#### CITY OF ALBUQUERQUE

RE: Bubba's 33 10000 Coors Bypass NW Grading and Drainage Plan Engineer's Stamp Date: 03/19/21 Hydrology File: B14D004H

- PO Box 1293 Based upon the information provided in your submittal received 03/22/2021, the Grading & Drainage Plan **is not** approved for Building Permit. The following comments need to be addressed for approval of the above referenced project:

**PRE/POST  
LAND USE  
COMPARISON**

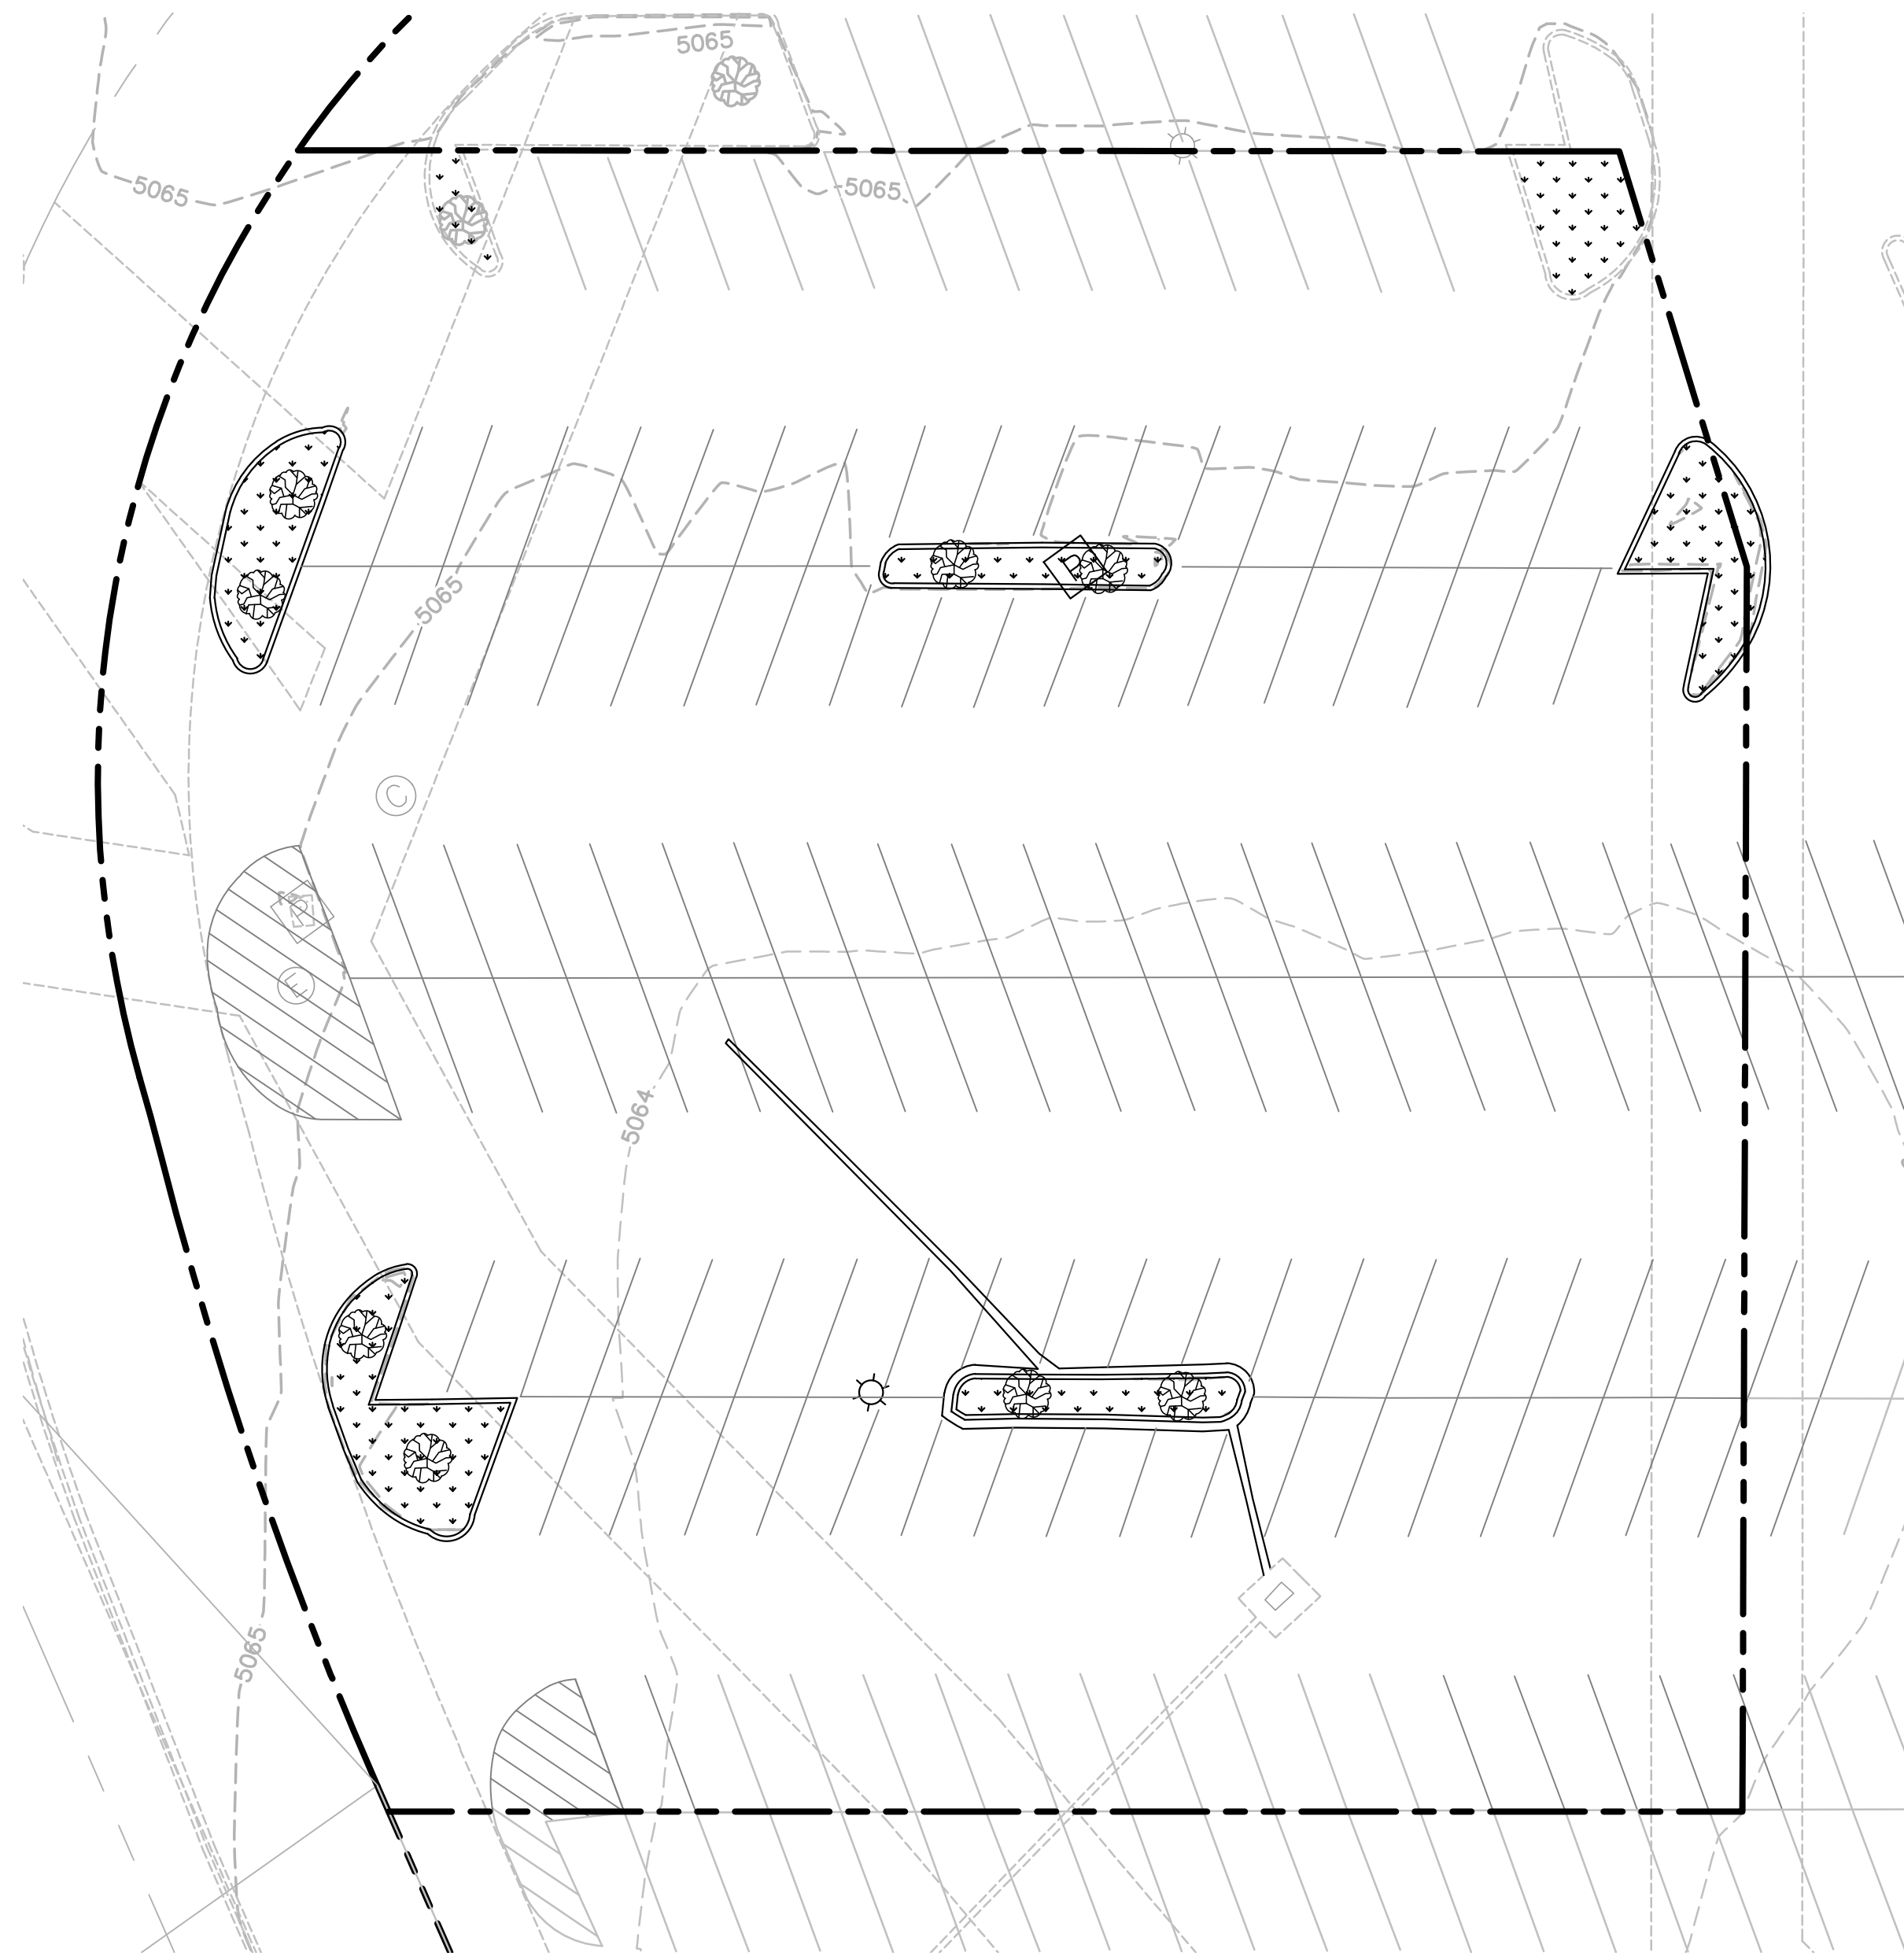
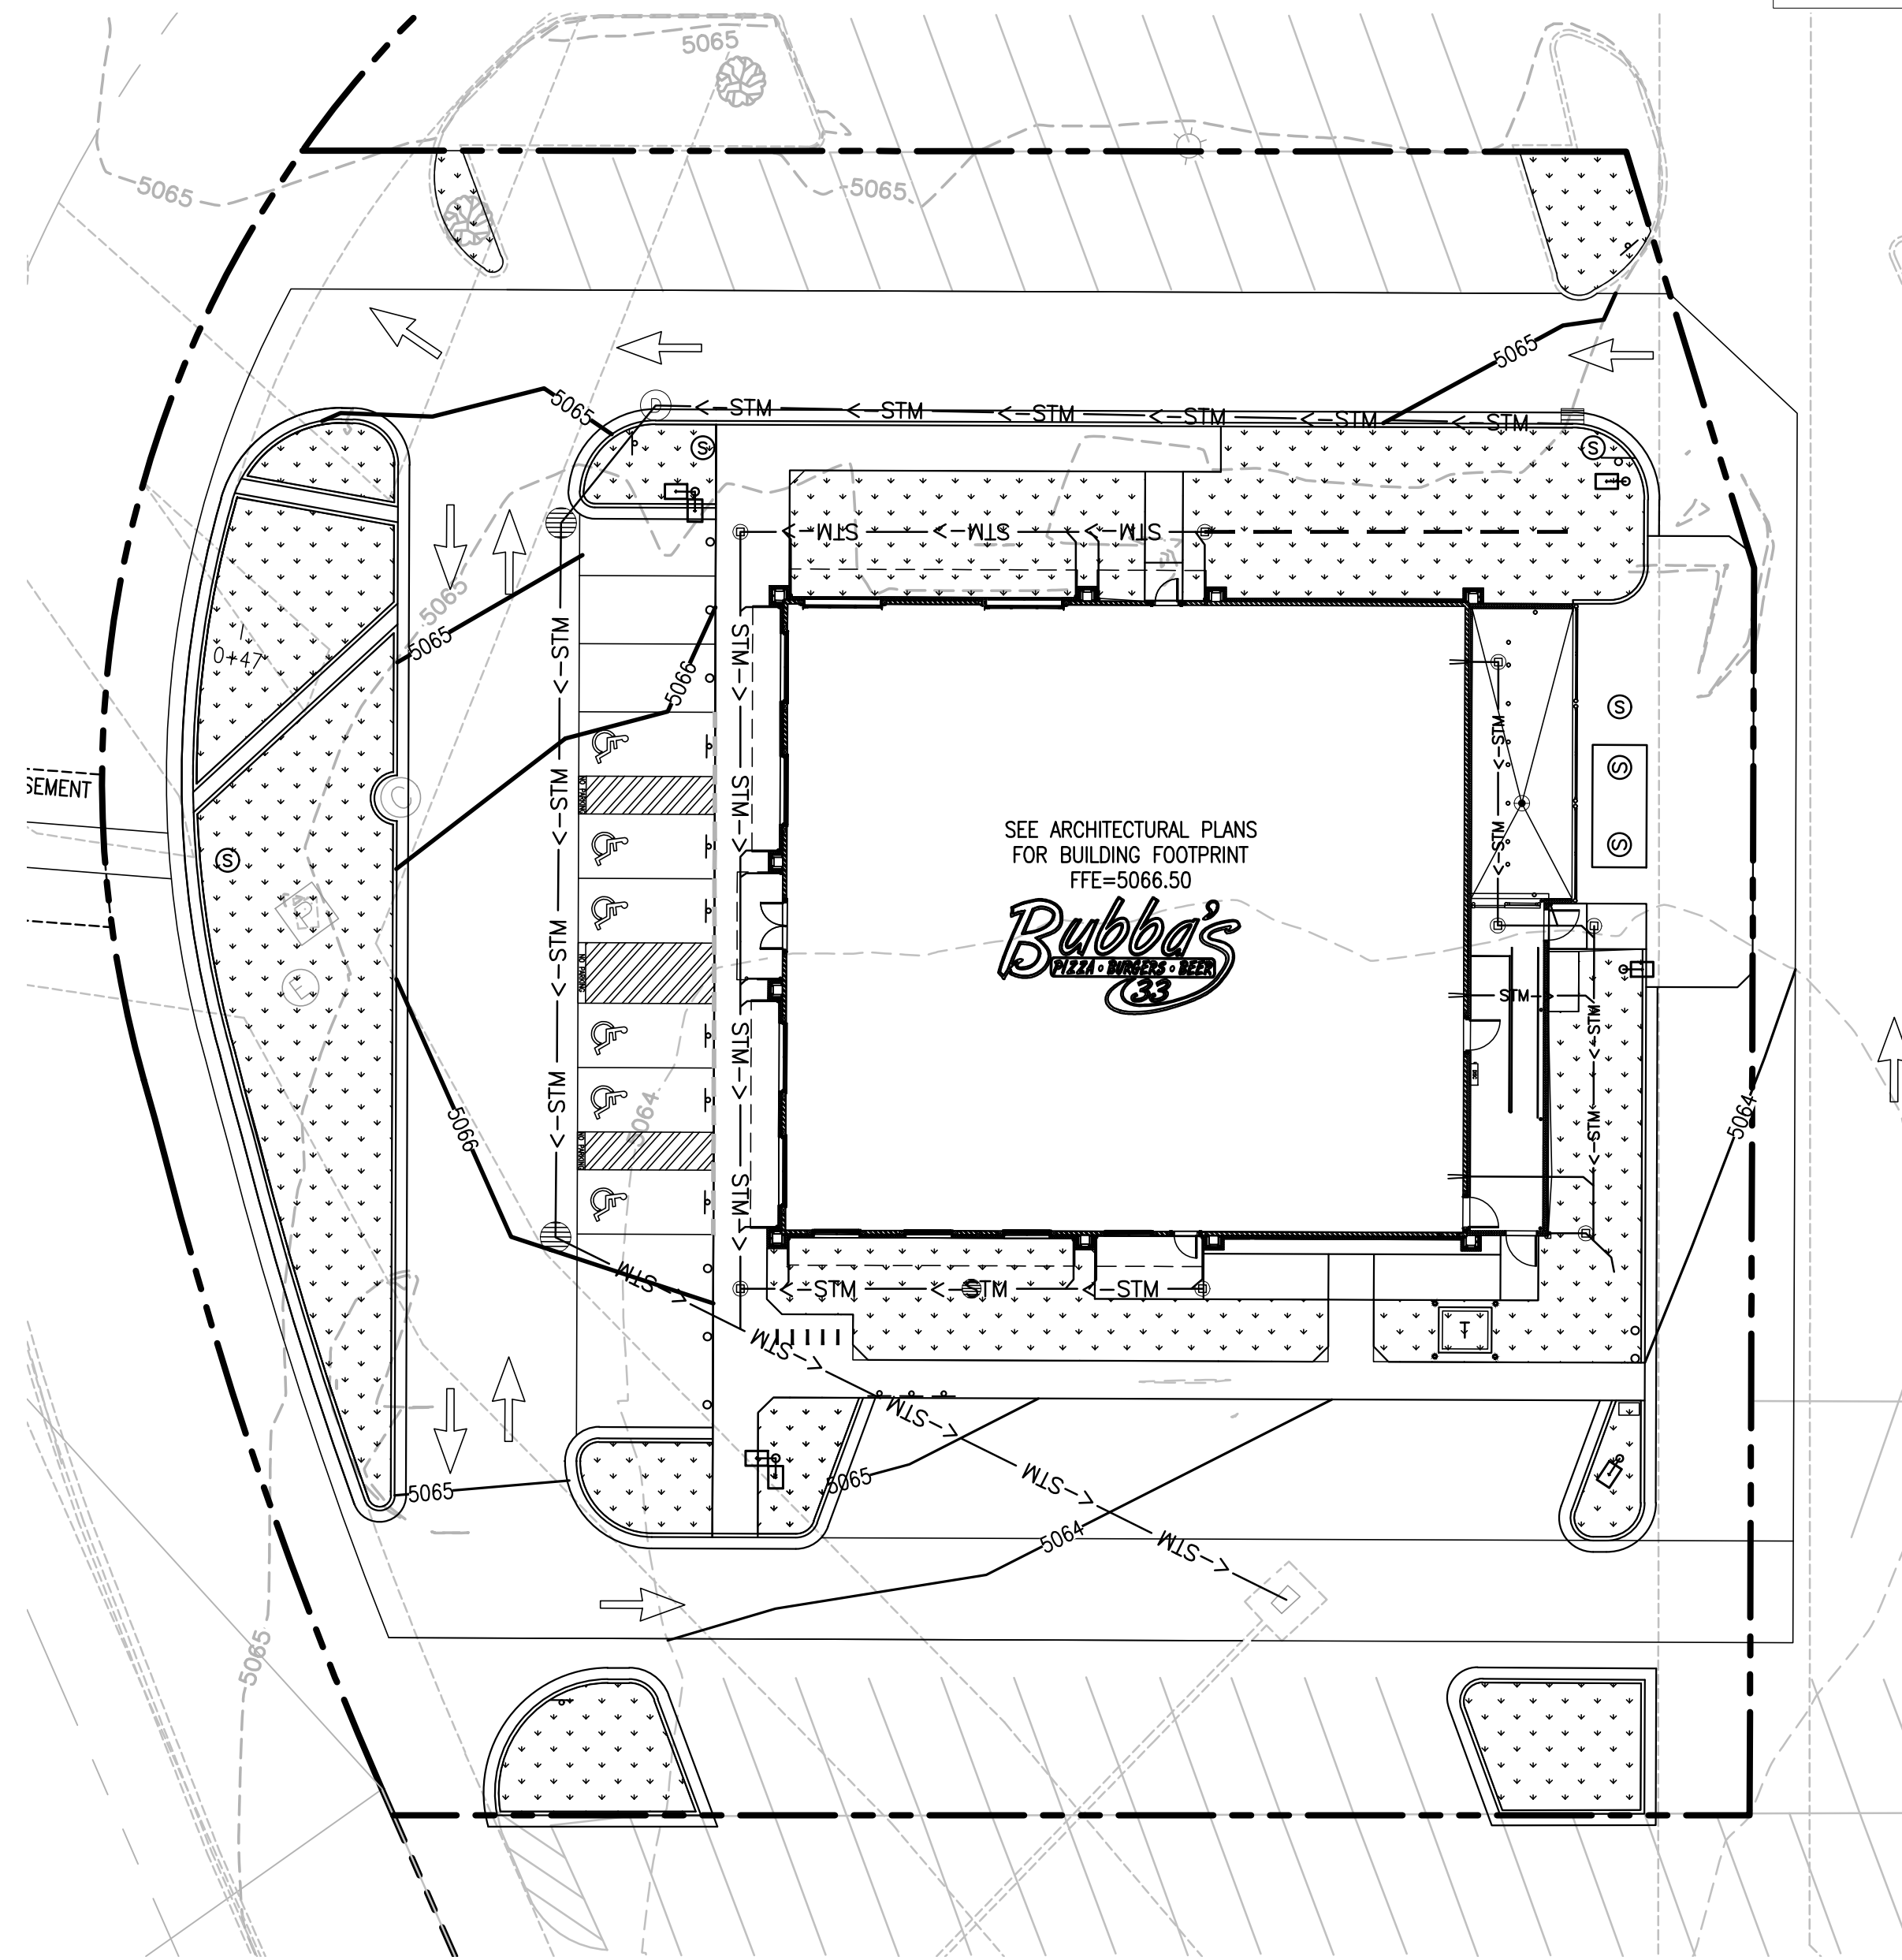
- Albuquerque 1. Please use the procedure for 40 acre and smaller basins as outlined in Development Process Manual (DPM) (signed 06/08/20) Article 6-2(a). Please provide both the existing conditions and proposed conditions for the 100-year 6-hour storm event.
